GM Urban Design & Architecture
Studio 803, Level 8
75 Miller Street
North Sydney NSW 2060

GMU Reference: 15230

Date: 17/06/2016

Re: Supplementary Submission to the State Significant Development Application and Variation of the Sydney Cove Redevelopment Scheme for the 'Remediation, Renewal and Adaptive Re-Use of Campbell's Store', The Rocks (SSD 7056).

Section Title
SECTION - BAY 12 SOUTH

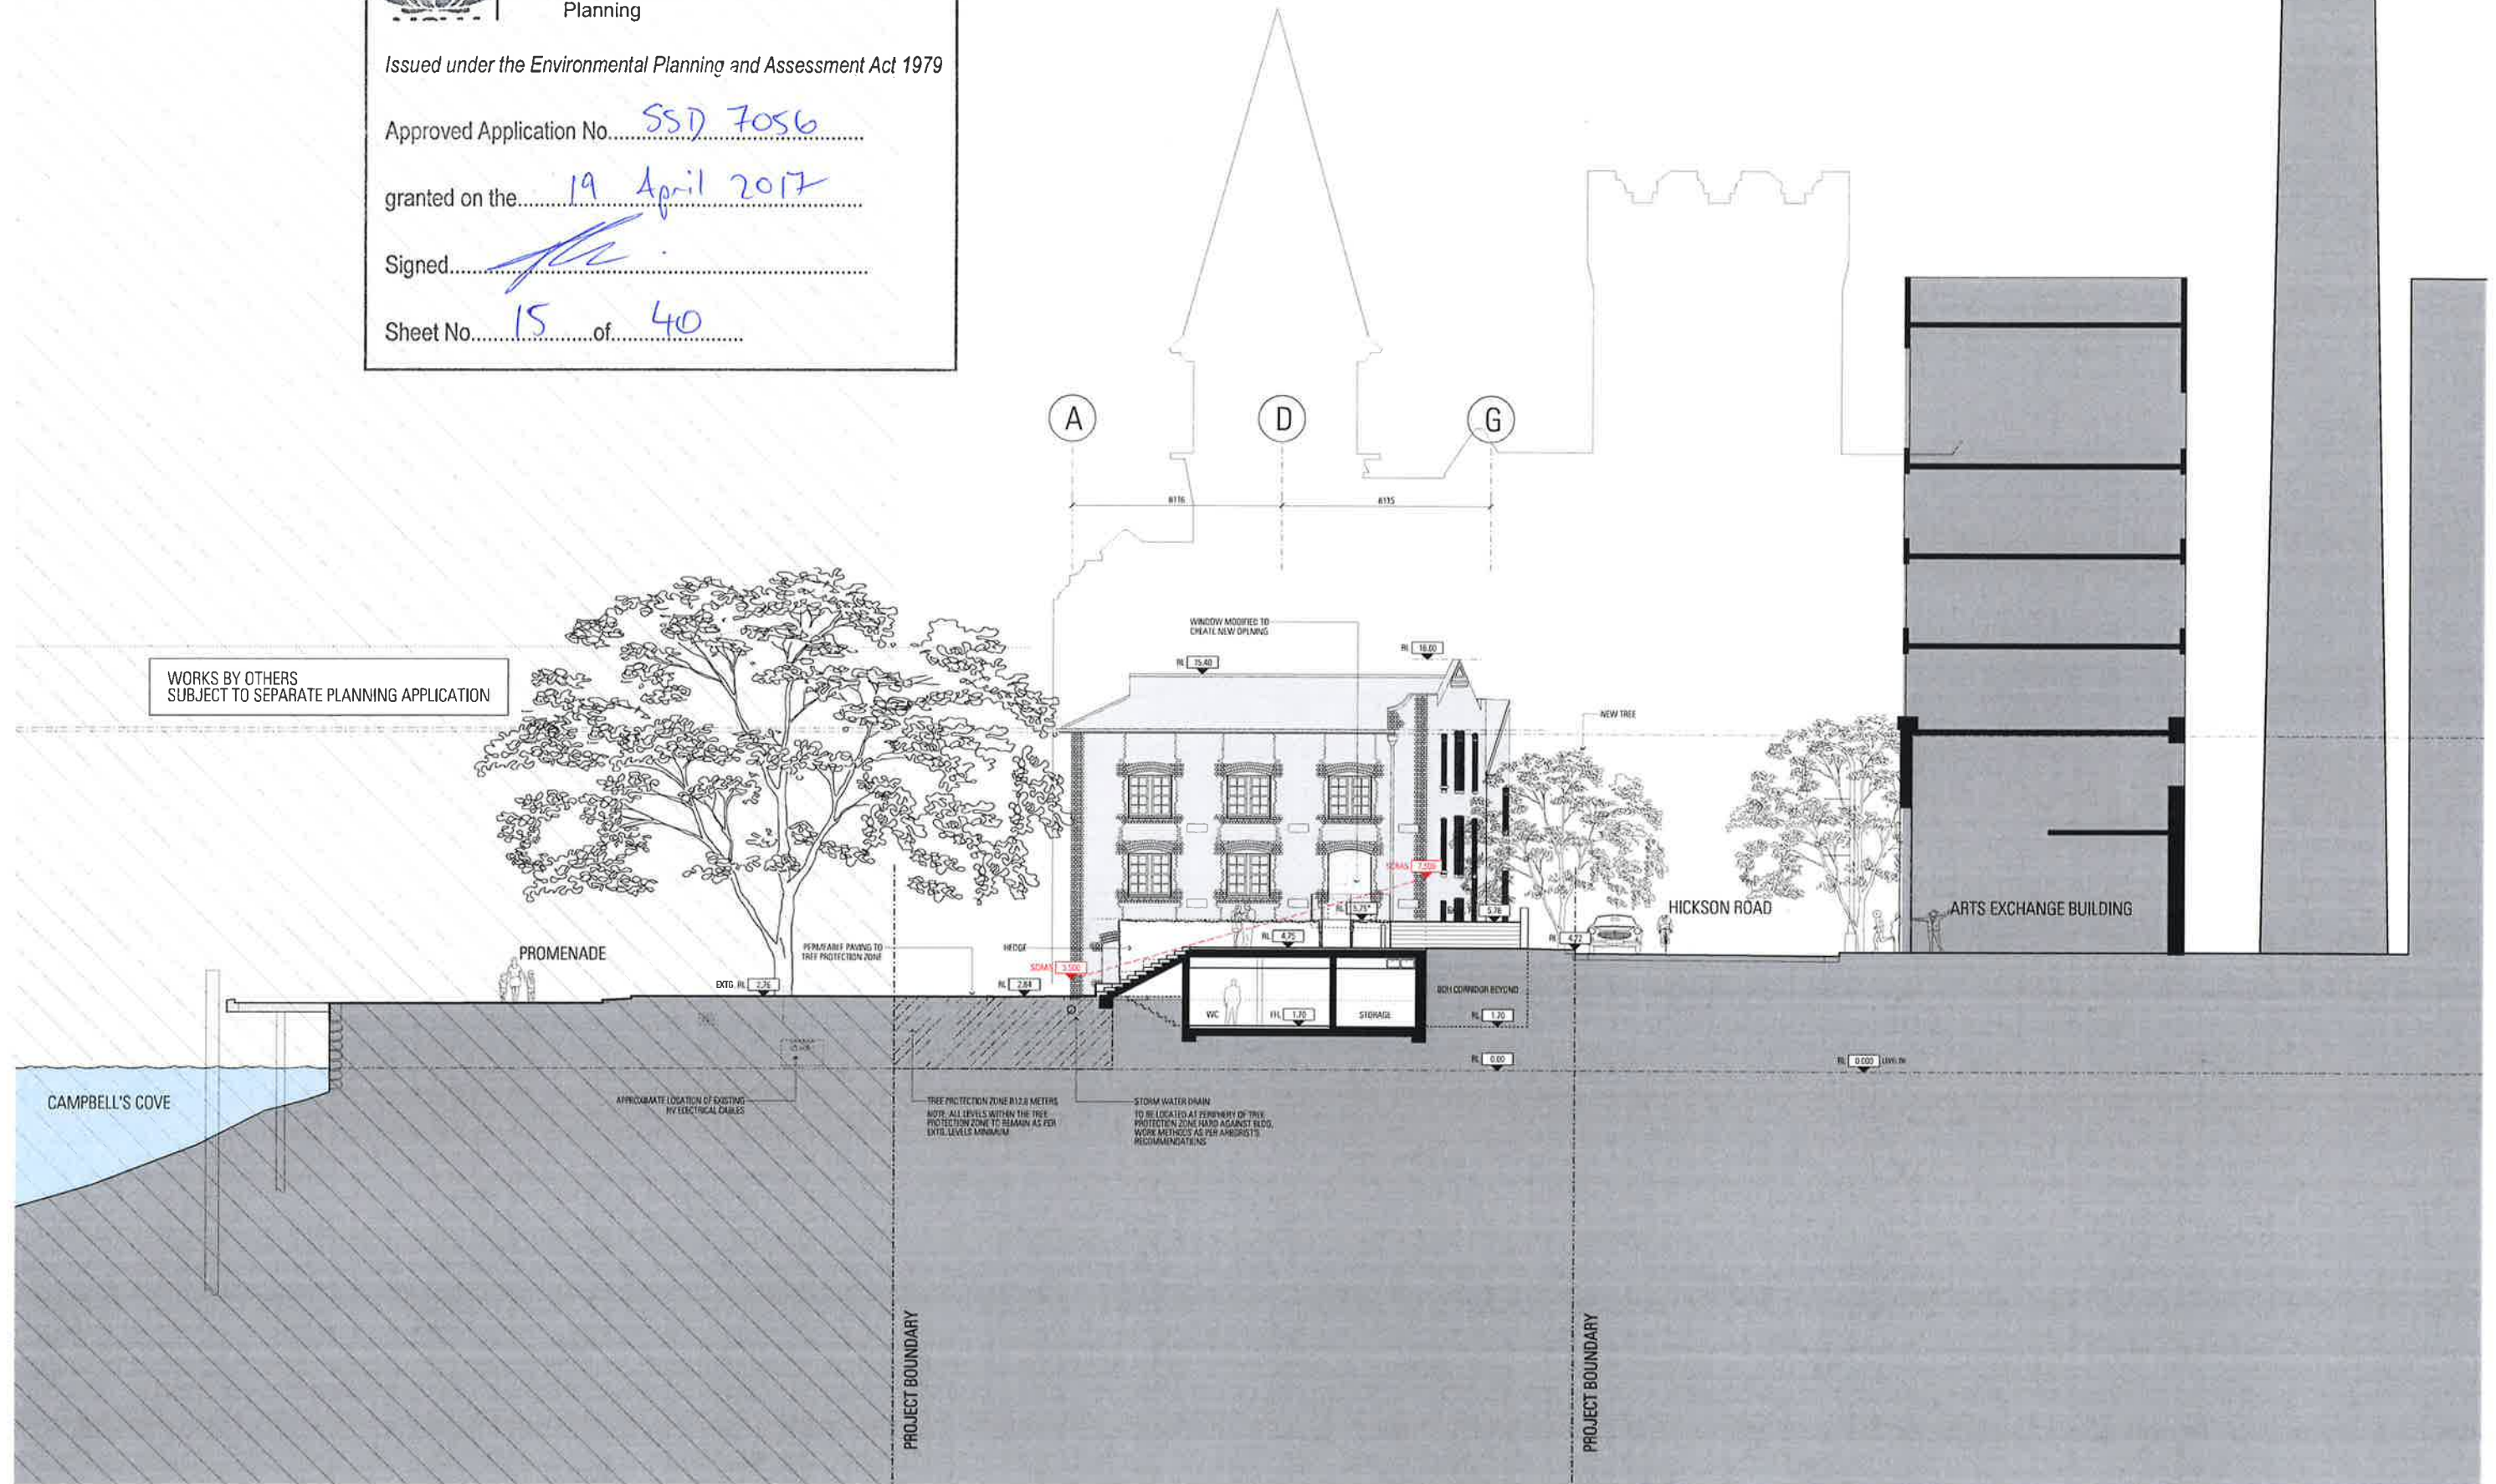
water and Opera House. The Response to Submissions by Urbis (page 30) states that the space “will be activated by a coffee and/or ice cream cart” to invite a broad cross-section of the public. However, from an urban design point of view, the proposed undercroft space with a height of 2.5m does not provide sufficient space to enable open views and to encourage public access. On the contrary, the low ceiling undercroft area on the ground level deactivates the public domain and does not have sufficient height to become an attractive open space or an effective view corridor, which is an undesired outcome.

According to the assessment, the revised Bay 12 building still exceeds the height restriction to an RL level of 17.4m including lift overrun. Its proposed glass block facades and cubic form presents a new urban fabric and built form that does not sensitively respond to the prominent character of the heritage buildings. This infill development in a contemporary bulky form with a narrow separation distance of 4m to the Campbell’s Stores will detract from the pristine nature of the remarkable heritage buildings. The proposed height and density will also physically increase the enclosure of public open space between the Campbell’s Stores and the Park Hyatt Hotel. The proposed undercroft area with a height of only 2.5m will not successfully form an inviting open space for the use of general public.

Drawing Title:
SECTION - BAY 12 NORTH

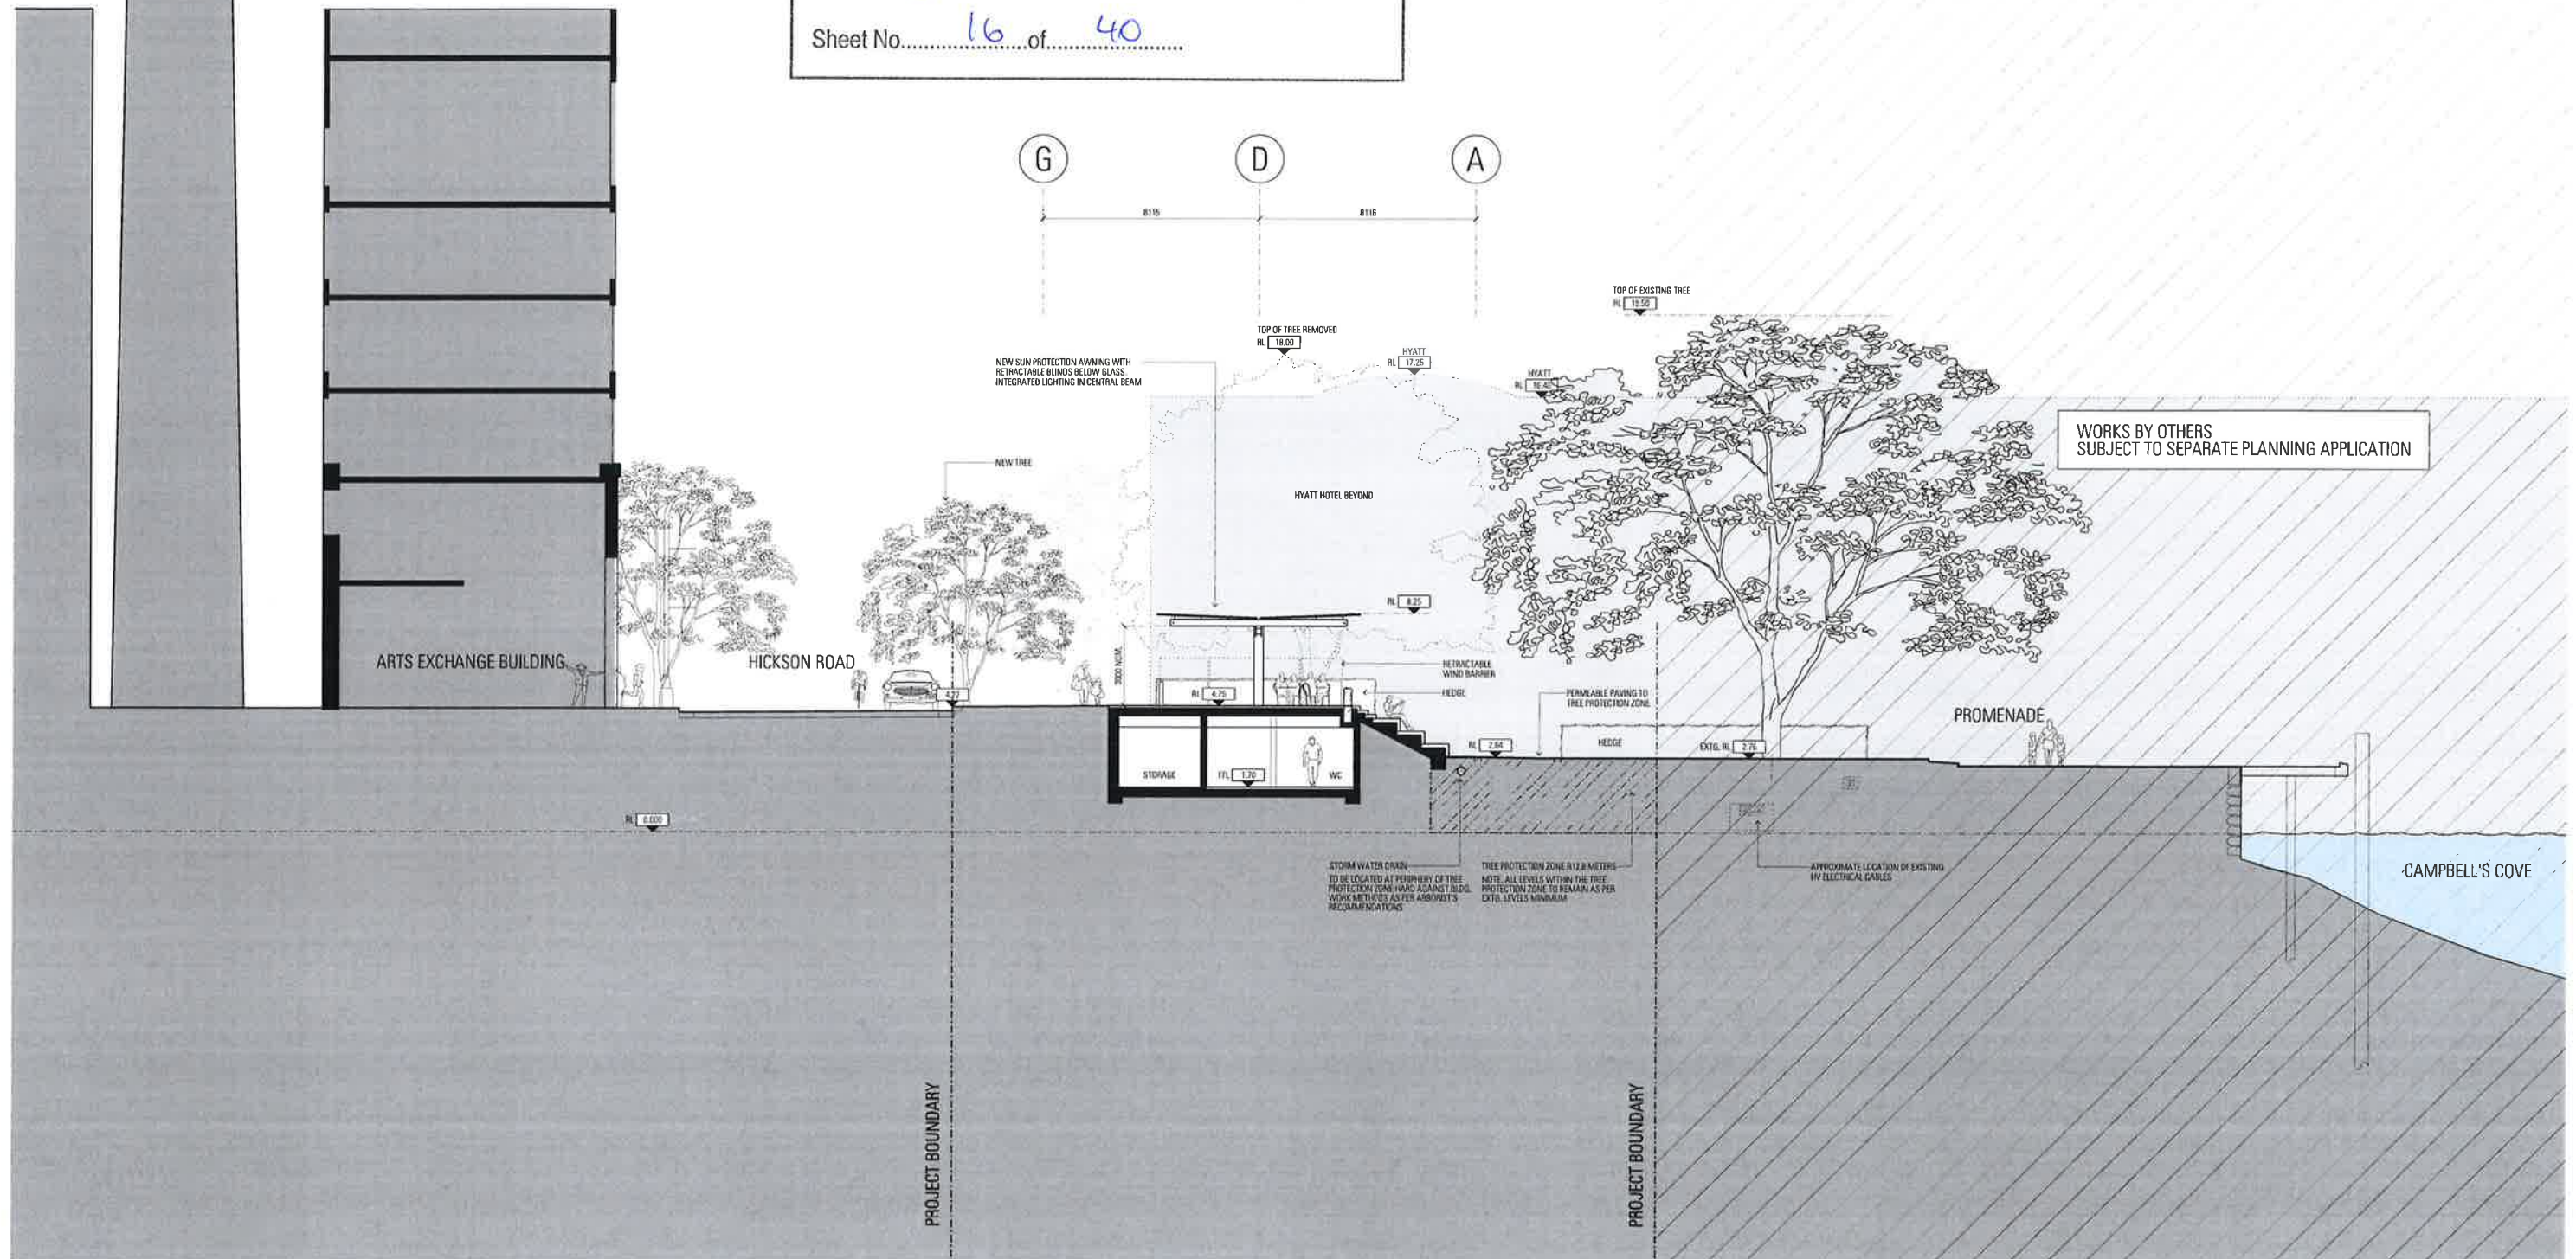
The Bay 12 building with a vertical core stack for circulation along the northern boundary is 10m south of the Park Hyatt Hotel. It creates a physically defined edge which obstructs visibility to the publicly accessible foreshore area and limits spatial connection to the waterfront. This is contrary to the design concept of *‘creating an uninterrupted public access from Hickson Road to Campbell’s Cove through the subject site’*. The existing separation distance of approximately 26m, as measured from SIX map, reduces to approximately 10m at the eastern end of the opening to the Park Hyatt Hotel, according to JPW’s Design Response- Executive Summary Diagram (page 5). This is representative of a 62% reduction in separation distance which will increase the ‘sense of enclosure’, density and scale and irreversibly alter the rhythm of open space to built form for this section of the precinct. The existing separation distance between Bay 1 and ANSC building is approximately 21m, 90% more than the proposed opening at the other end, which will be reduced to approximately 10m. Therefore, the openings to either side of the existing bays will be unequal and unbalanced. The raised ground level of Bay 12 building will also affect the north façade of Bay 11 where it abuts the existing windows and doors.

FIGURE 26 – VIEWPOINT 10 – SOUTHEAST CORNER OF CAMPBELL'S COVE, SYDNEY FORESHORE – VISUALISATION

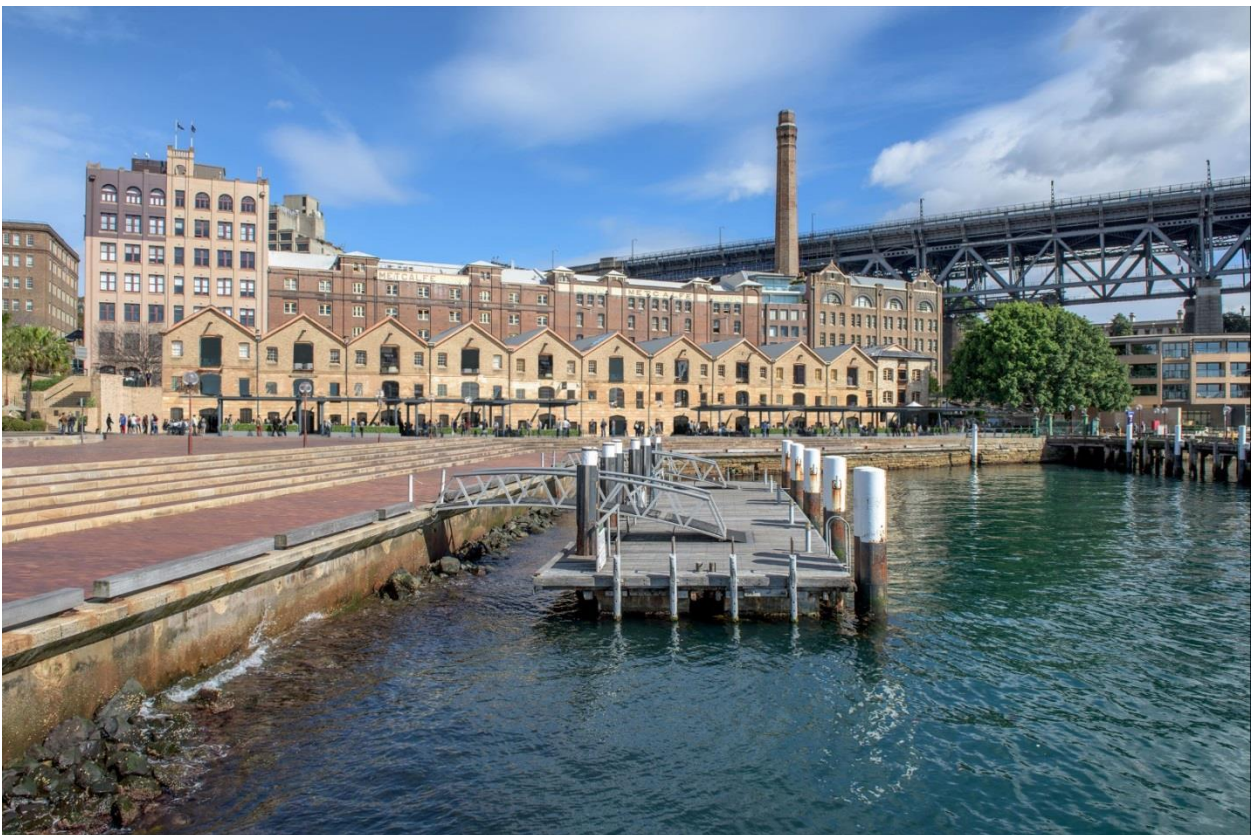
The visual analysis presented in the response to submissions suggests that there would be no view impacts on the residents at 8 Hickson Road; however, the proposed Bay 12 building silhouetted in white rendering shows that the proposed built form does not sensitively respond to the significant historic setting in Campbell's Cove and the existing foreshore alignment. Taking the proposed façade design and materials into consideration, it appears to be a solid cubic form filling in the open space gap when viewed opposite from Hickson Road. Therefore, the perceived bulk and scale of the proposed Bay 12 building appears to be greater than the Campbell's Stores and visually apparent from numerous viewpoints according to the visual impact assessment.
